COMMUNITY DEVELOPMENT DEPARTMENT
501 Delta Avenue ♦ Marysville, WA 98270 ♦ (360) 363-8000

Re: Kids N' Us – *Tech Review 1*
PA23013

RE: Kids n Us, File# PA23-013
New Childcare Facility
8287 Soper Hill Road

SUBJECT: PA 23-013 White Barn-Kids N Us, March 2023 TIA &/or response#

SHEET DESCRIPTION:  
**PRELIMINARY SITE PLAN**

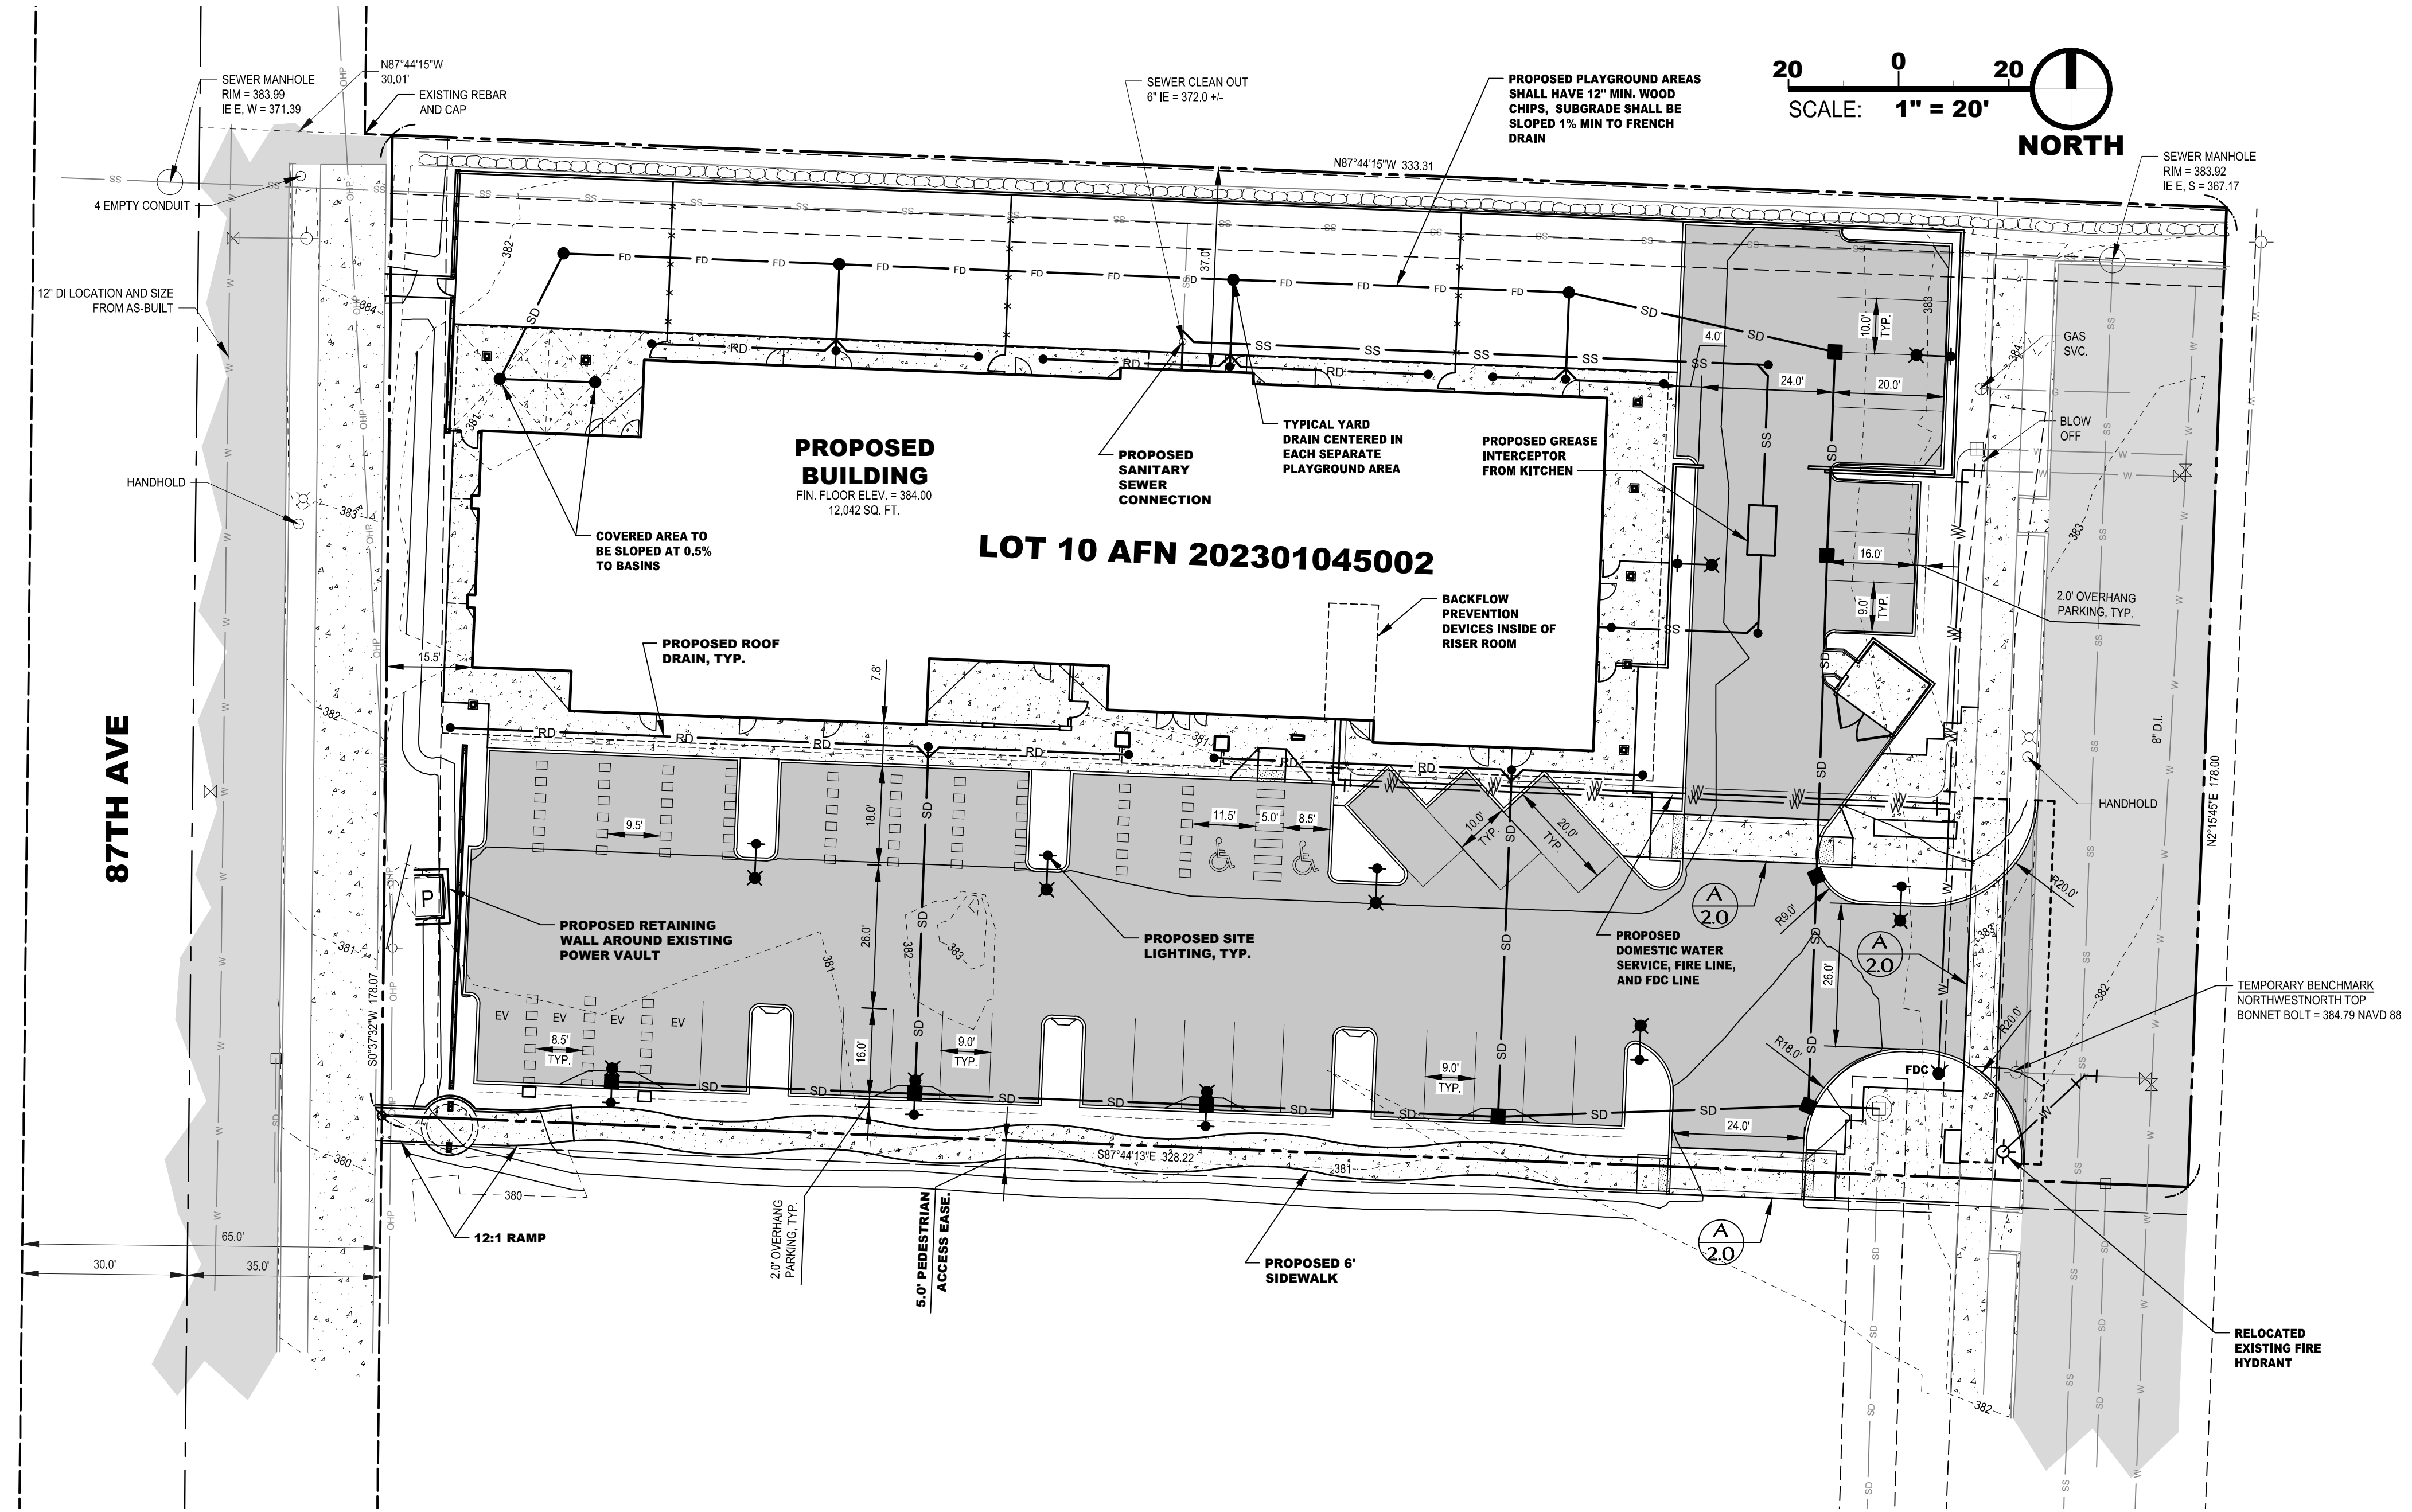
1. Include File No. PA23013 on all future plan submittals.
2. Amend Sheet A-1.00 and Sheet C-2.0, depicting all encumbrances (easements) outlined in the Title Report, prepared by Chicago Title Insurance Co., dated May 16, 2023. If you cannot depict the easement then provide a reference including Auditor's File Number.
3. Amend the landscape plan to include columnar shaped deciduous trees 5' from the back of sidewalk on 87th Avenue NE planted at a rate of 1 per 40'.
4. Submit a photometrics plan and design specifications for the proposed site lighting to determine compliance with [MMC 22C.070.160](#).
5. Submit color elevation drawings with your formal building permit submittal in order for the Planning Division to conduct design review to ensure compliance with applicable standards outlined in [MMC Chapter 22C.070 East Sunnyside – Whiskey Ridge Subarea – Design Requirements](#).
